State Significant Development Response to Submissions

31 Wheat Road, Sydney

Redevelopment of IMAX Building

March 2016 ■ 12255

SALE @ B1	DRAWN	CO-ORD	REVIEWED	APPROVED
200	RT	JO	JO	CW
PROJECT NUMBER	DRAWING NUMBER			REV
004409	ARC-HSL-DD-SK-018.2			-

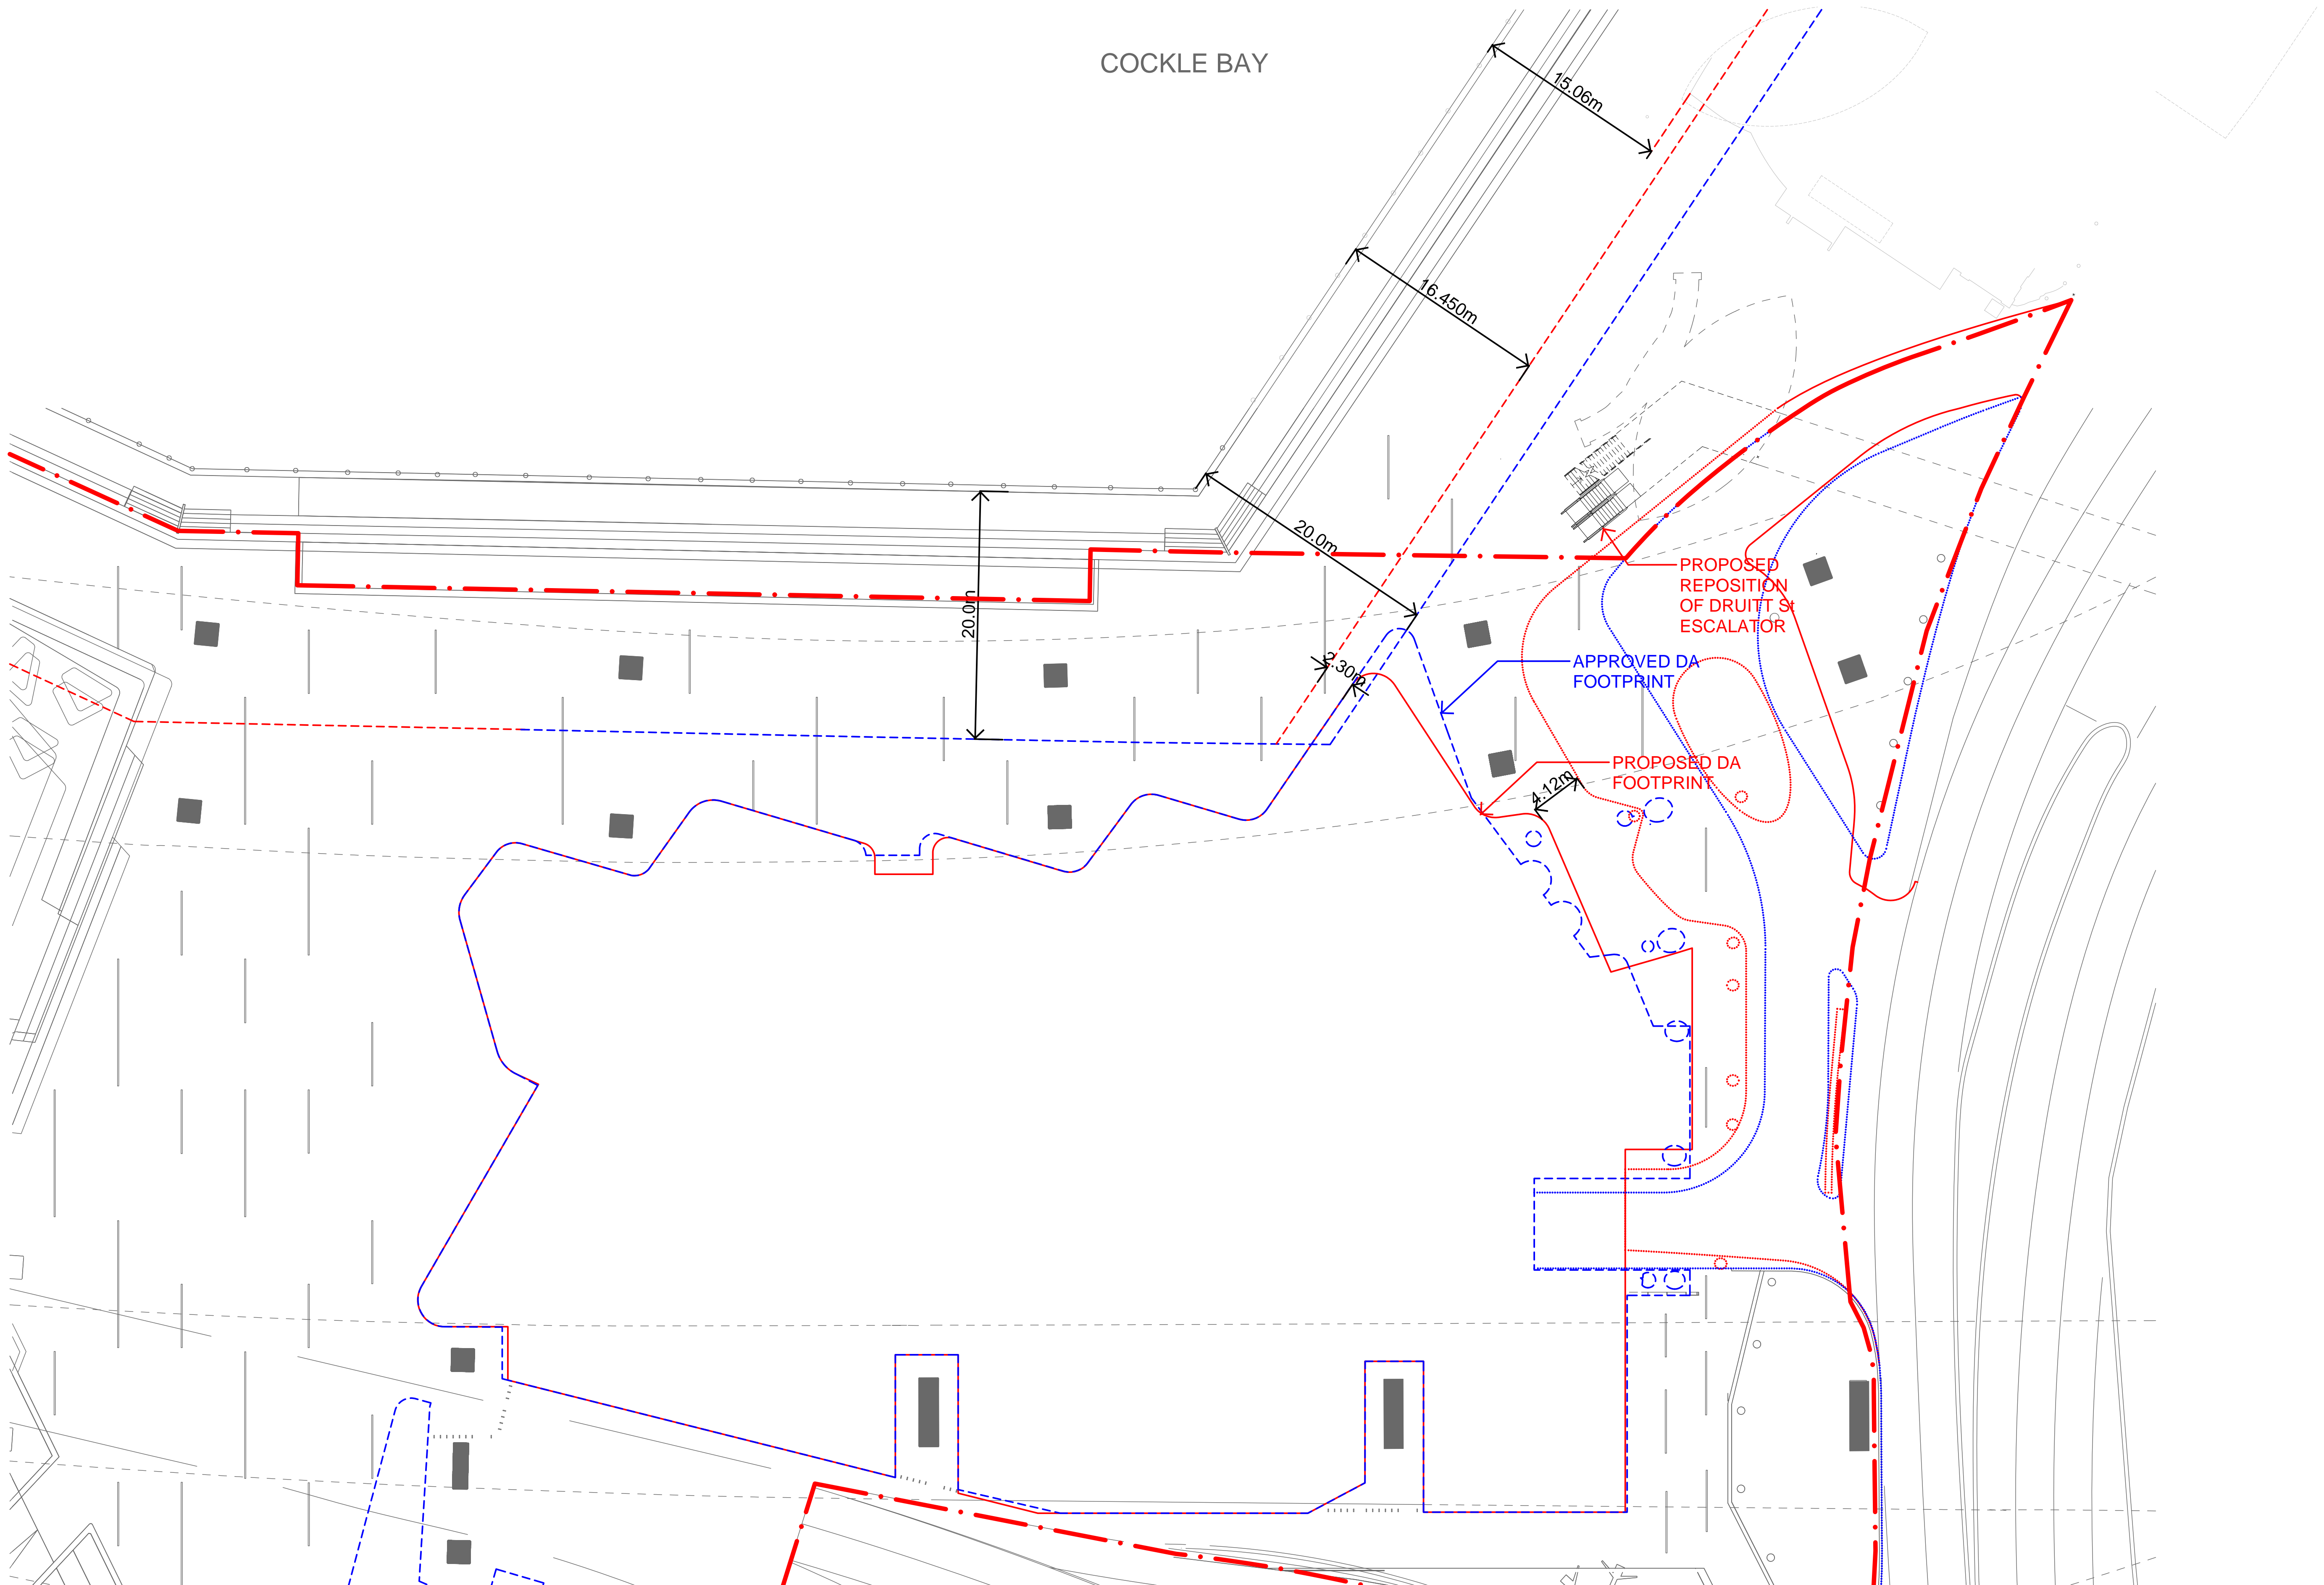
Details were requested in relation to bicycle parking and end of trip facilities. Internal bicycle parking and end of trip facilities are shown on drawings ARC-HSL-DD-SK018.1 and ARC-HSL-DD-SK018.2 prepared by HASSELL, and external bicycle parking is shown on drawing 12023-LA-105 prepared by Aspect Studios (refer **Appendix C** and **D** respectively).

A total of 239 internal bicycle parking spaces are provided, in addition to 70 lockers and seven showers. A total of 56 external bike parking spaces are provided, with the opportunity to expand this provision to a total of 100 spaces if required.
